**WELWYN HATFIELD BOROUGH COUNCIL
EXECUTIVE DIRECTOR - PLANNING, PUBLIC PROTECTION AND GOVERNANCE**

DELEGATED APPLICATION

Application No: 6/2021/0250/VAR
Location: Stanborough School Lemsford Lane Welwyn Garden City AL8 6YR
Proposal: Variation of condition 3 (approved drawings) on planning permission 6/2019/2587/VAR
Officer: Mr Raymond Lee

6/2021/0250/VAR

building + drawing title
**Proposed Music & Drama Block
Site Plan**

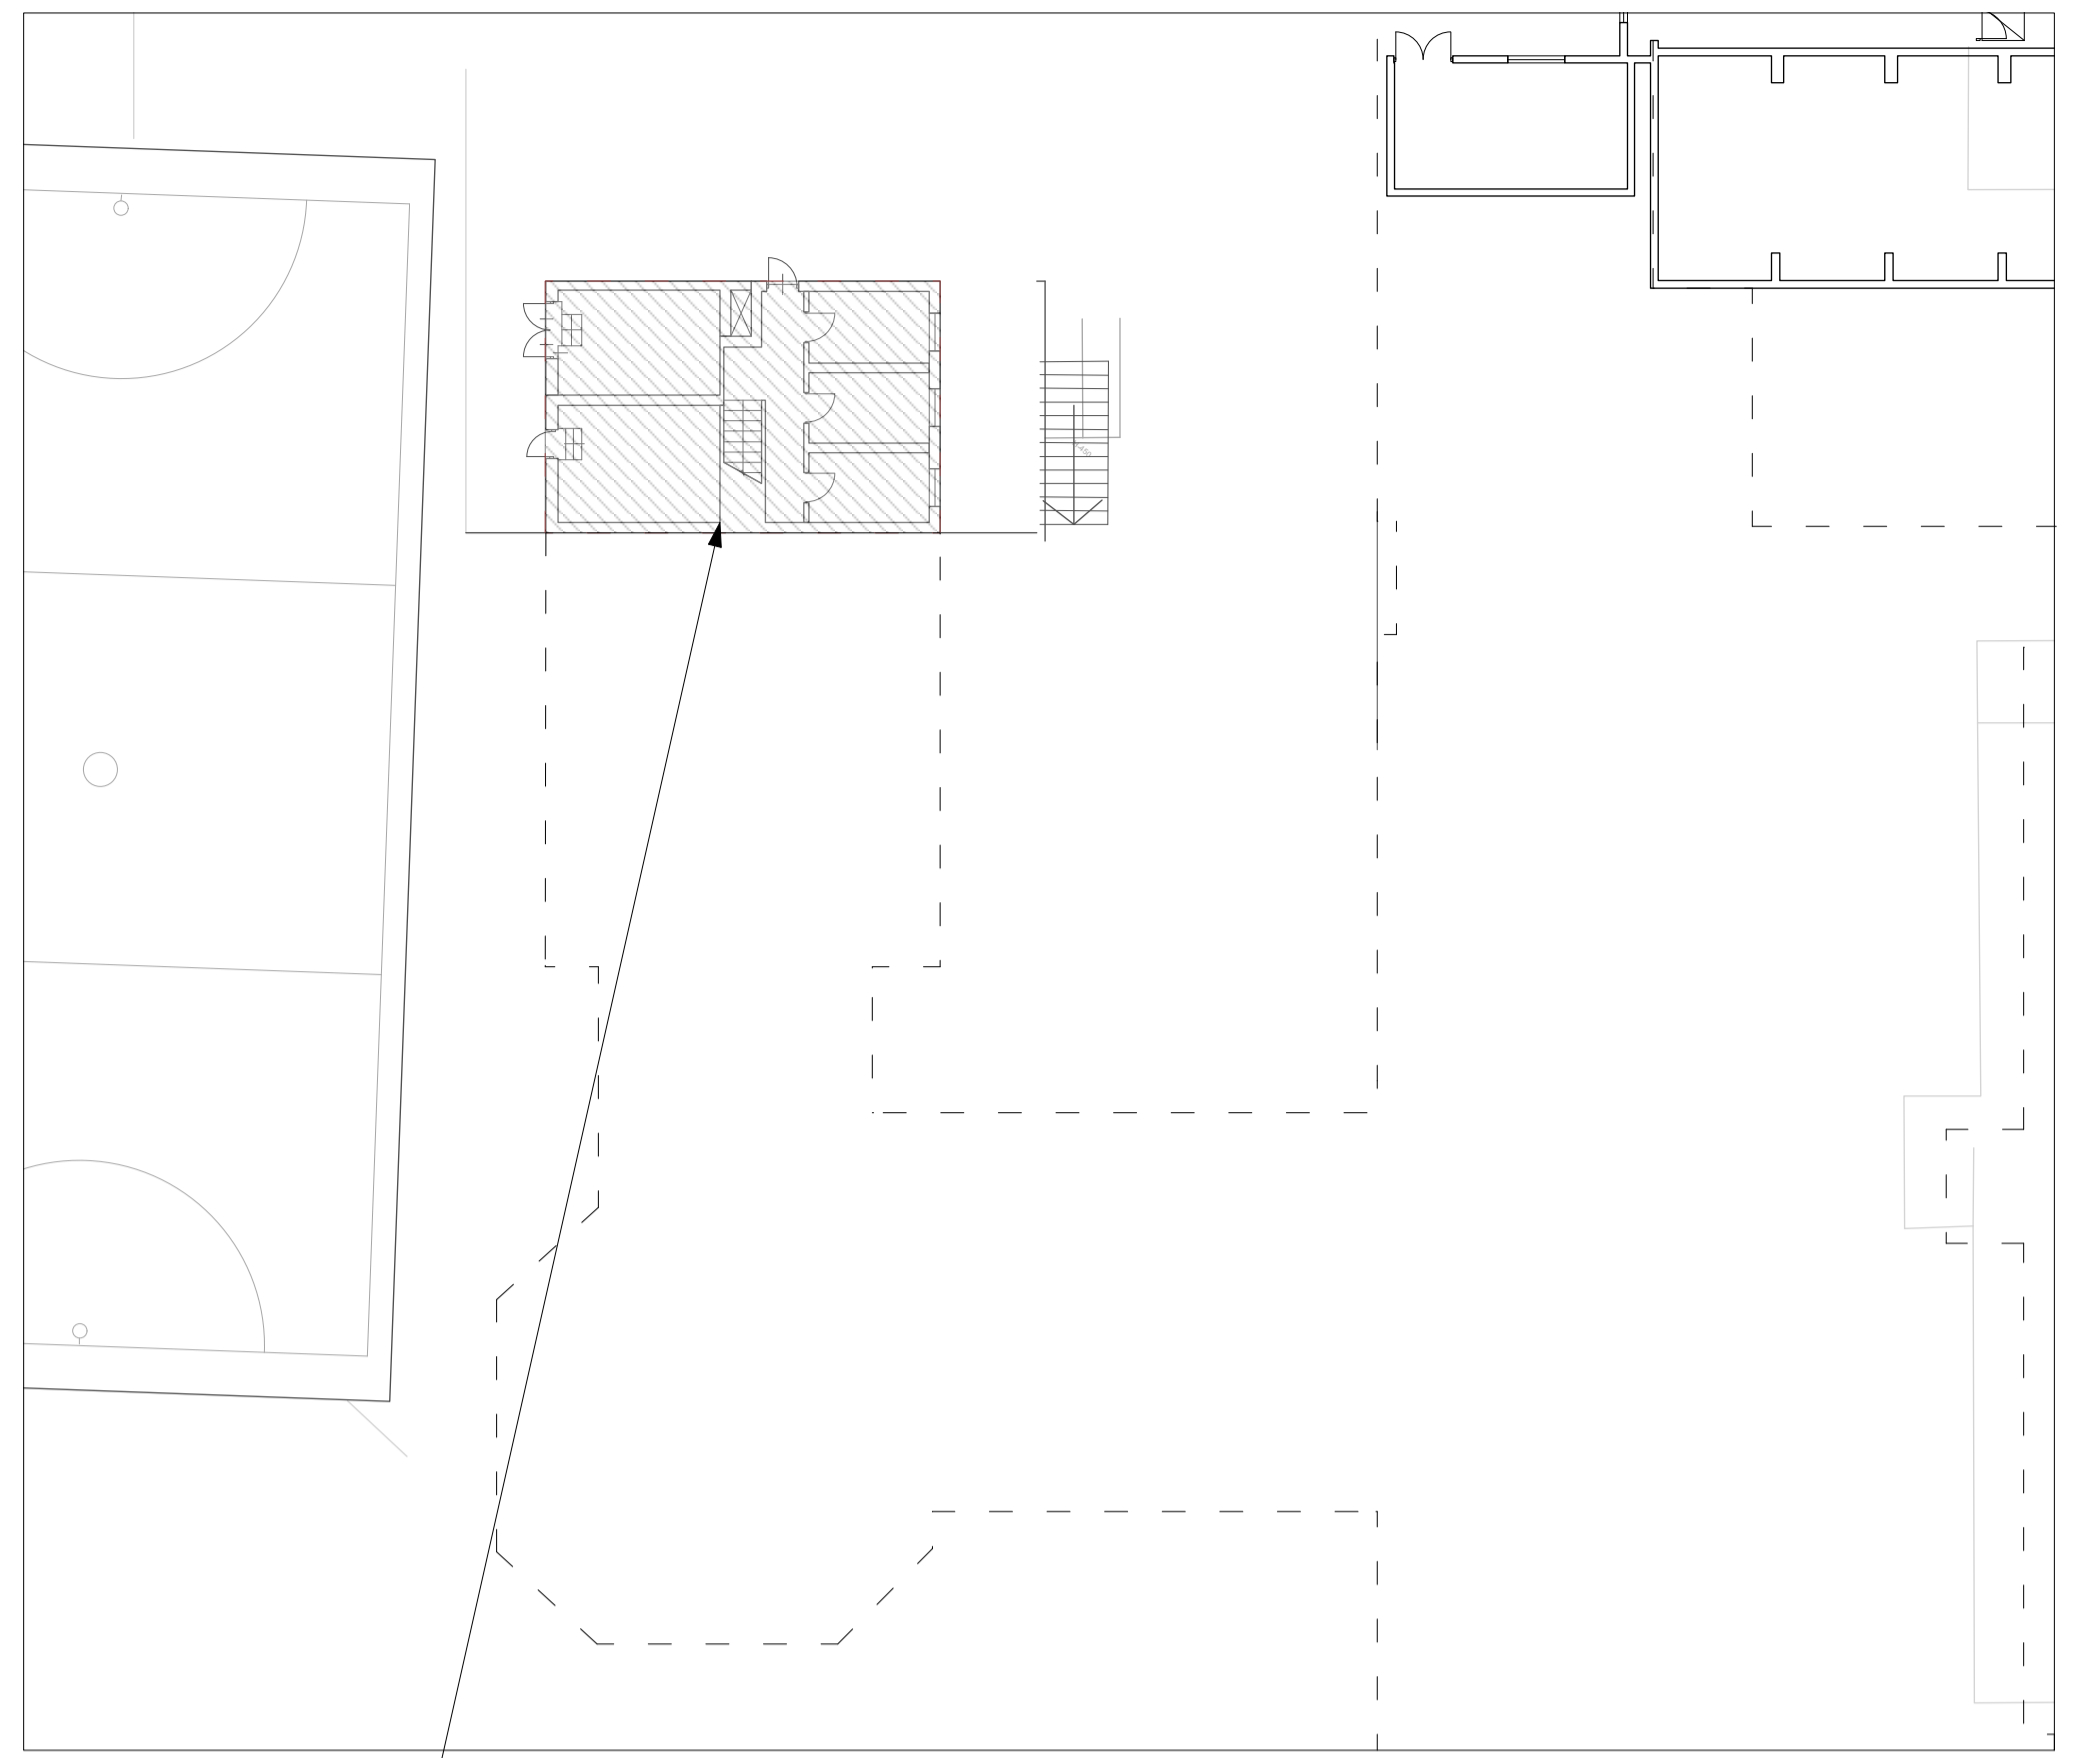
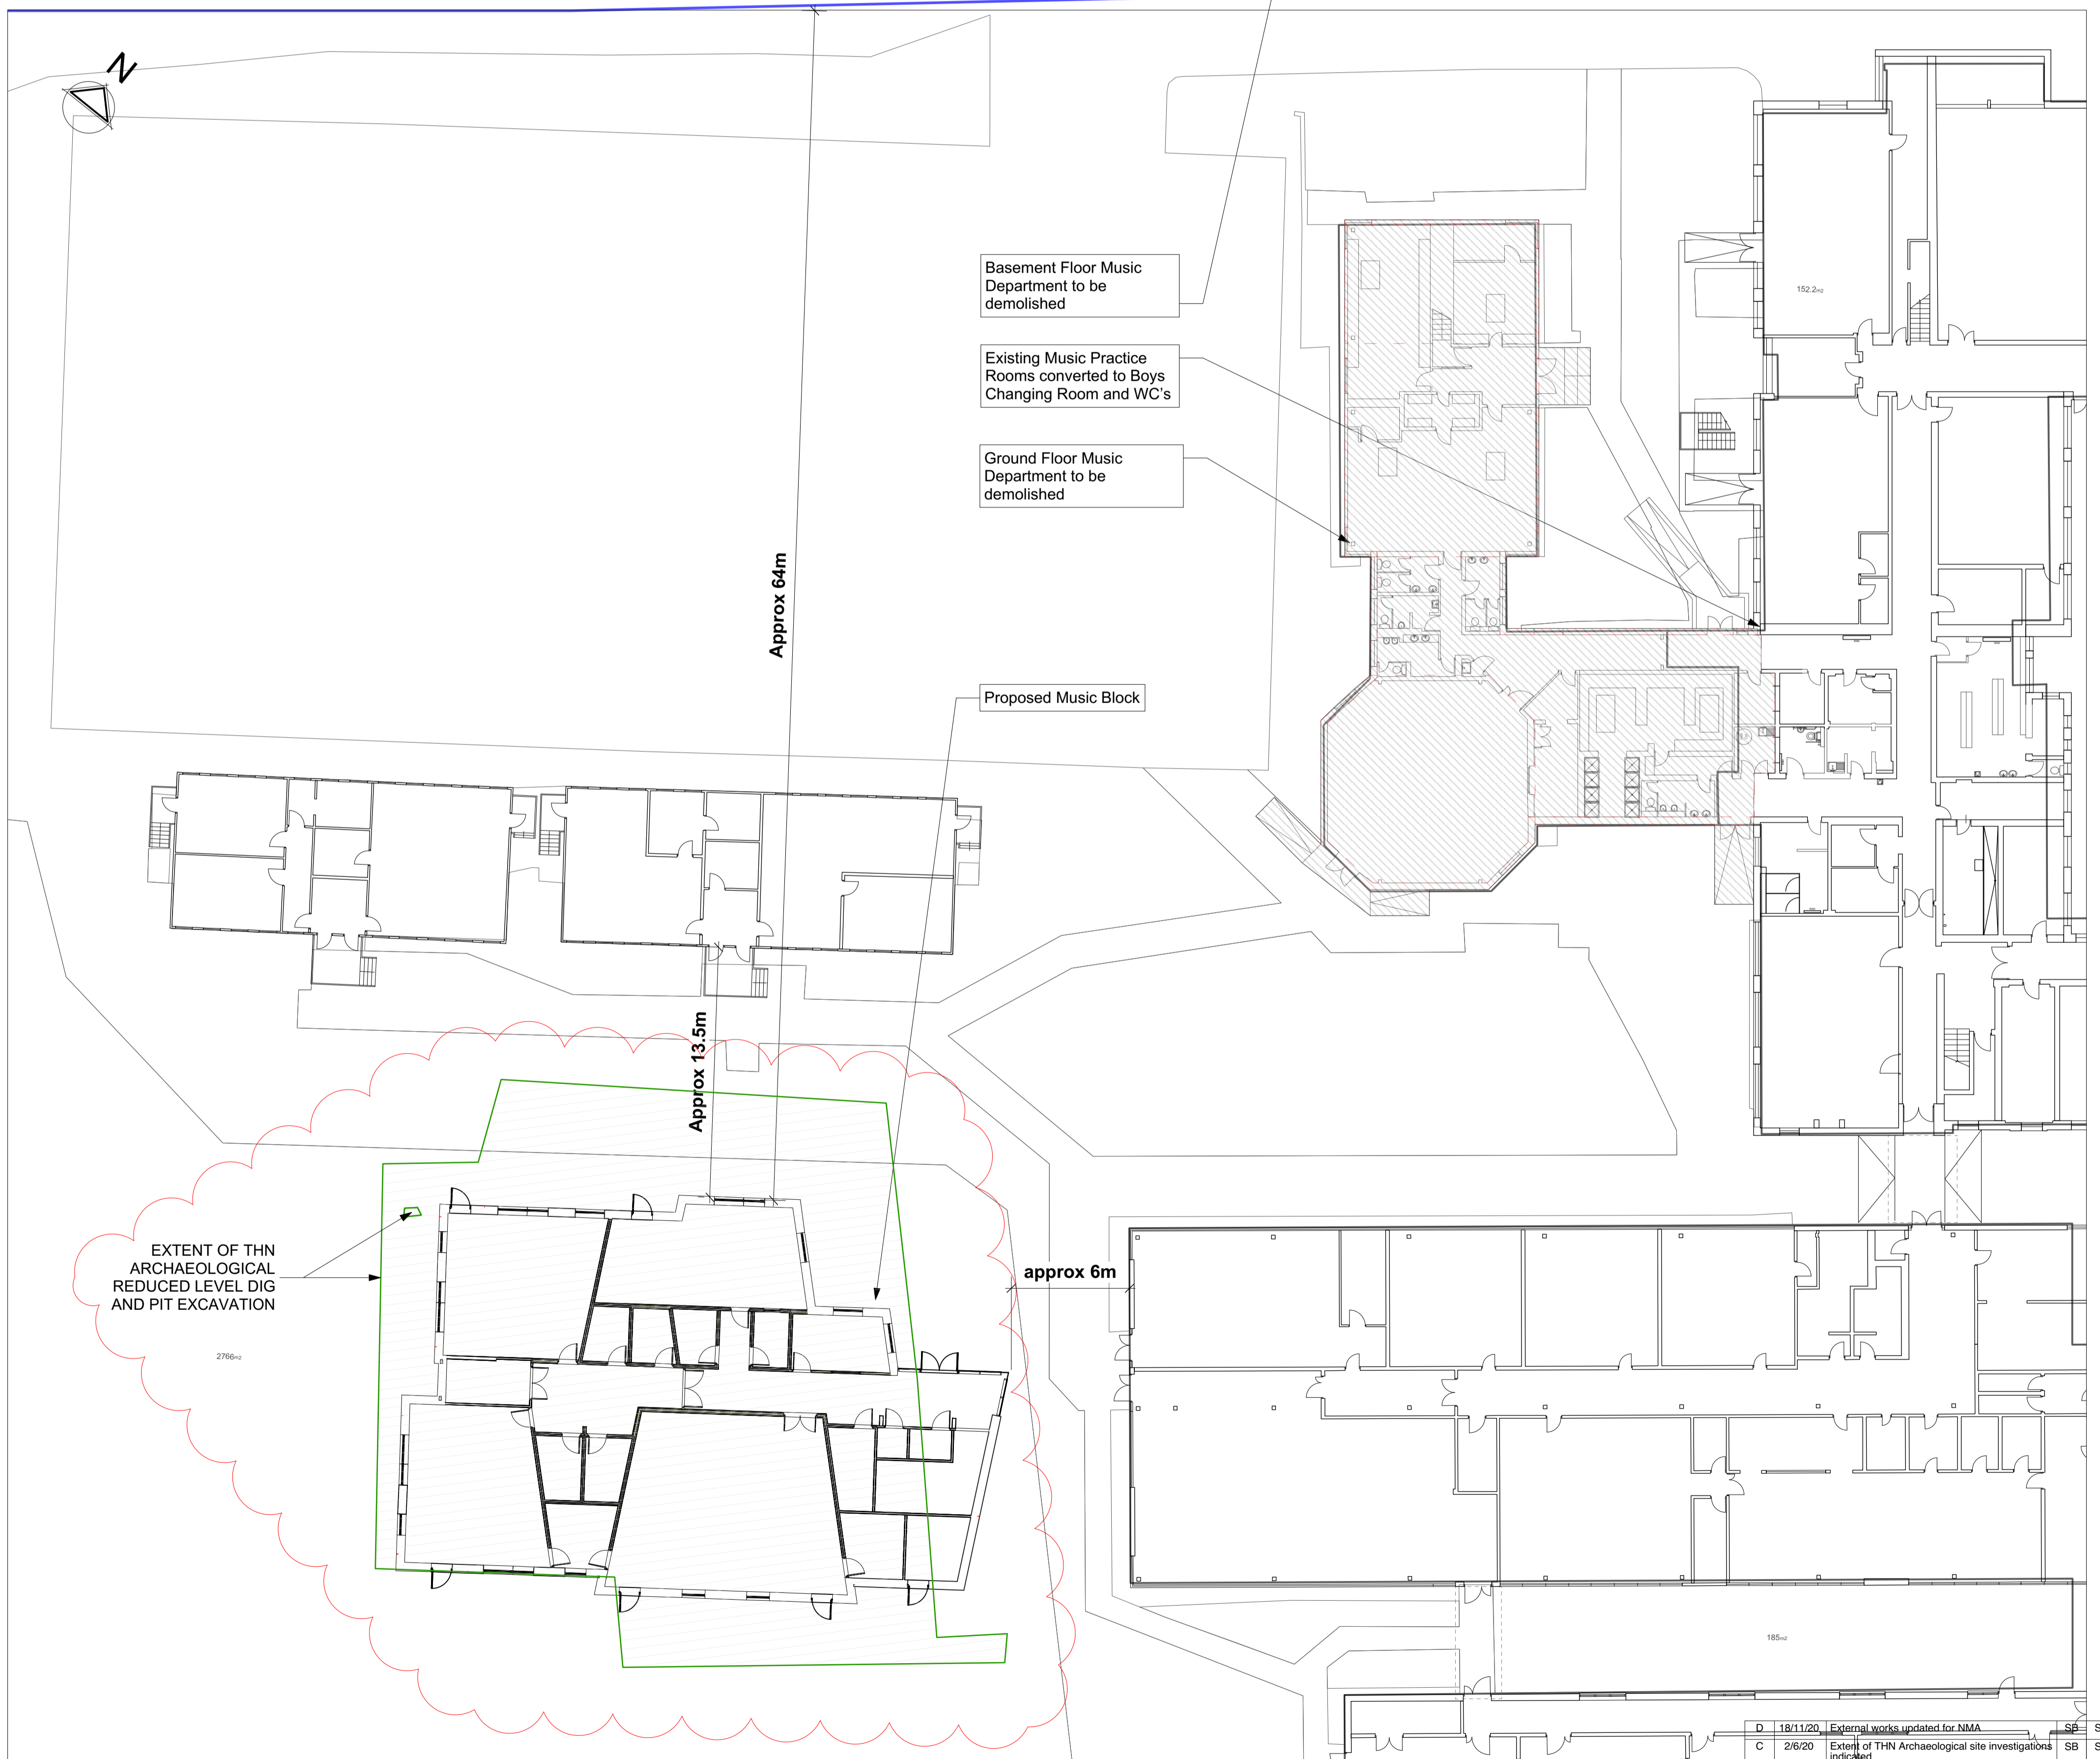
This proposal seeks permission to vary permission 6/2019/2587/VAR to include a revised area of the demolished old Music and Drama block. The alterations involve the omission of the previously approved hardstanding and the 2.2m tall retaining wall to make way for a grass embankment that would be formed using retained soil material on site. The adjacent area to the south which was approved to be a grassed is now proposed to be reinstated in tarmac to increase the hard recreation area for the school. According to the submitted plans, the levels would not be significantly altered as a result of the works. Whilst the current proposal seeks a greater amount of hardstanding at the site, there would be generous amounts of soft landscaping and grass pitches remaining at the school site.

As for the amendments around the new Music Block, this would include additional grass areas to the south-east and south west sides of the building. According to the plans, there would also be a very slight realignment of the building itself however the location, appearance, footprint and occupancy remain unchanged from the approved application.
